**SOUTH DUBLIN COUNTY COUNCIL'S PLANNING AUTHORITY'S REPORT TO
AN BORD PLEANALA ON**

APPLICATION FOR FURTHER DEVELOPMENT CONSENT UNDER SECTION 37L

**AT BEHAN'S QUARRY
WINDMILL HILL, RATHCOOLE, COUNTY DUBLIN**

**Land Use Planning and Transportation Department
South Dublin County Council
County Hall
Tallaght, Dublin 24
Prepared by: Tracy McGibbon
Date of Report: 18th August 2021**

Figure 11.5: Diagram in DN-GEO-030-060 used to determine the required Merge Layout.

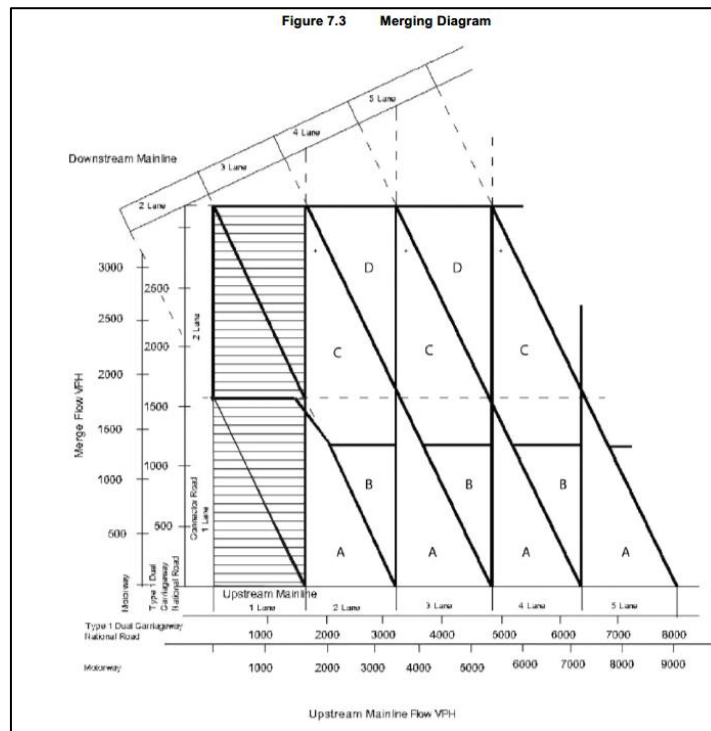
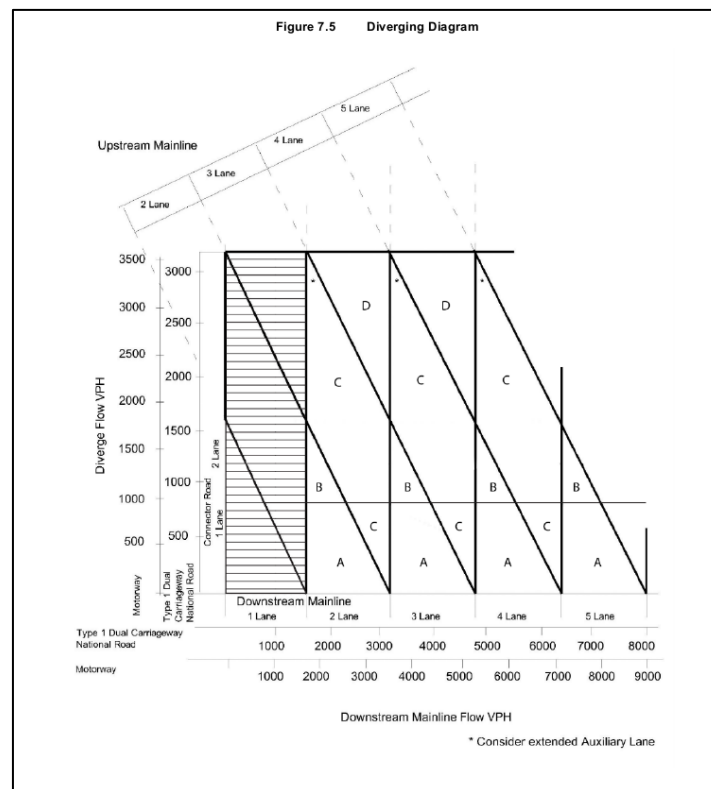
The applicant should also be requested to submit a revised site entrance layout onto the N7 conforming to the current TII guidelines on accesses onto National Roads. In particular, the revised layout should demonstrate conformity with the following key parameters:

- Nose length of 75m with a ratio of 1:25 to be provided for the merge, and a nose length of 70m with a ratio of 1:15 to be provided for the diverge;
- Auxiliary lane to be extended 160m for merge, 150m for diverge; and
- Auxiliary lane taper to be extended to 75m for the merge and 70m for the diverge.

SDCC roads department note the applicants blue line ownership extends approximately 350m east of the site entrance. The roads department do not understand why the necessary nose, auxiliary lanes and tapers cannot be delivered.

The necessary land to the west of the site entrance is also in the ownership of the applicant. The access layouts for the merging and diverging lanes connecting to the N7 should be upgraded and improved in accordance with the current TII design requirements.
